From: Simon Davis
Sent: 27 September 2013 14:02
To: [REDACTED]
Subject: Proposed Fitness Equipment at Land at Rookery Farm REF FP/159/13/

SUBJECT: FP/159/13

Change of use from production of timber for bio mass use (Sui Generis) to land for private outdoor fitness training (D2 Assembly and Leisure) (resubmission of FP/102/13/). This application is a Departure from the Development Plan.

Land at Rookery Farm, Worms Lane, Flansham, West Sussex

Site Plan

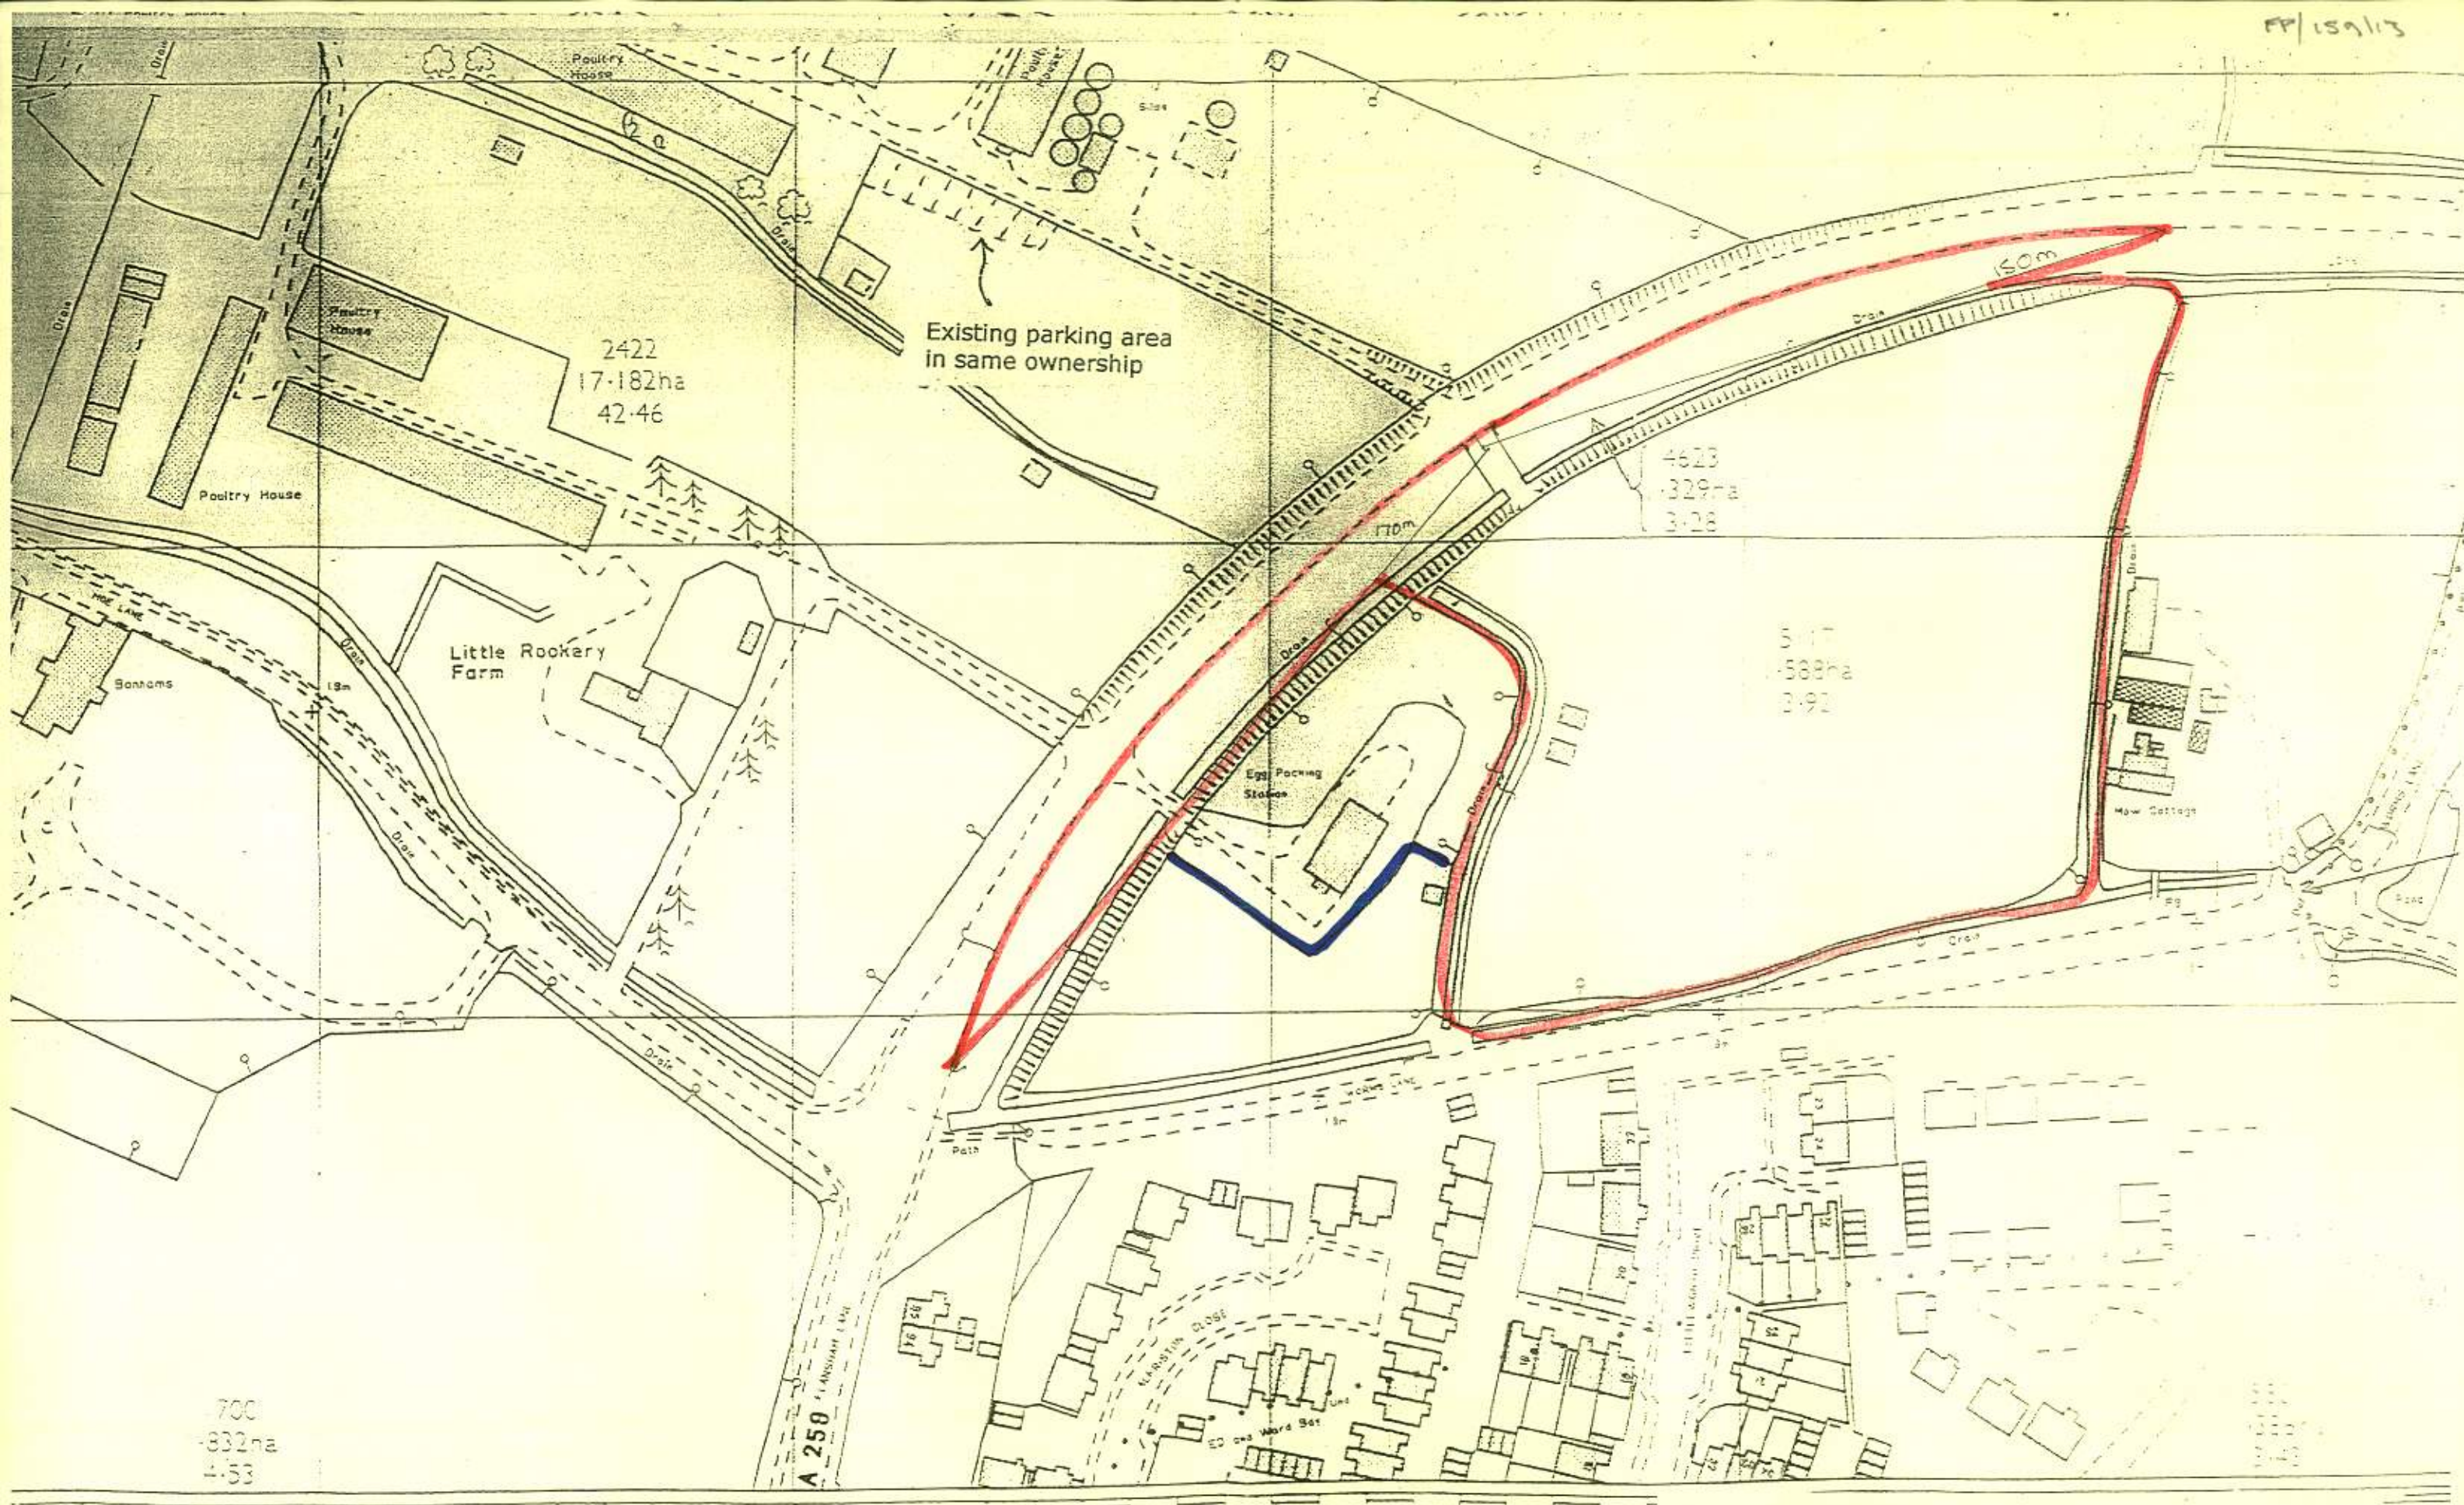
It has not been demonstrated that safe and suitable access to the site can be achieved by all people as required in paragraph 32 of the National Planning Policy Framework (NPPF), that the proposed access arrangements will not present a risk of death or injury due to transport incidents in accordance with the strategy 4 of the WSCC Local Transport Plan (LTP3) nor that the development allows for the safe movement of pedestrians and vehicles as required by Arun Policy GEN7 (vii).

The Applicant has stated that there will be no direct vehicular access to the site and that visitors will be expected to cycle or walk. Given the nature of the use it would be anticipated that the site would have a relatively large catchment area and that it is unlikely that all users of the site would be located within a reasonable walking or cycling distance from the site, or would be inclined to walk or cycle regardless of distance. Some users, such as groups of children or disabled users, are more likely to seek access by vehicle. Car parking will be made available at the existing Rookery Farm shop (although it should be noted that while this is under the control of the Applicant it is not included within the site boundary and the provision could be lost should this land change ownership) to the north of the A259 for those wishing to drive to the site. Pedestrians would be required to cross the A259 in order to access the site which is located to the south of the A259. Speeds along this section of the road are derestricted and daily traffic flows are high; while we do not have a counter at this specific location, an auto-counter further along the A259 shows the volume of traffic to be in the region of 15,000 daily movements and peaking at 1350 movements per hour, the equivalent of 1 movement every 2.5 seconds. Crossing opportunity would be limited and could result in pedestrians growing impatient and crossing at unsuitable times, running the risk of being struck by a vehicle travelling at speed.

Further to this, there are no pedestrian facilities along this section of the A259. Pedestrians would be directed to and from the bellmouth junction of Rookery Farm and onto a grass verge on the opposing side. Conditions would be worsened after periods of inclement weather where the grass verge may be wet or muddy and could result in pedestrians slipping onto the carriageway or encouraged to walk alongside until a suitable section of verge can be found. Such a provision would also be inappropriate for use by disabled users although use of the site is being promoted as such.

Pedestrians emerging from Rookery Farm to cross the road could obstruct the path of vehicles leaving the A259 to enter the Rookery Farm site and lead to rear shunt collisions between vehicles on the running carriageway who would not be expecting an obstruction to their journey.

The WSCC officer has also indicated that if the applicant is looking to overcome the issues then the installation of any form of pedestrian crossing at this location is not going to be acceptable. The demand wouldn't be there to make something like a light controlled or zebra crossing viable or safe not to mention the unsuitability given the speed. The only realistic option would be to look at direct vehicular access into the site from somewhere.
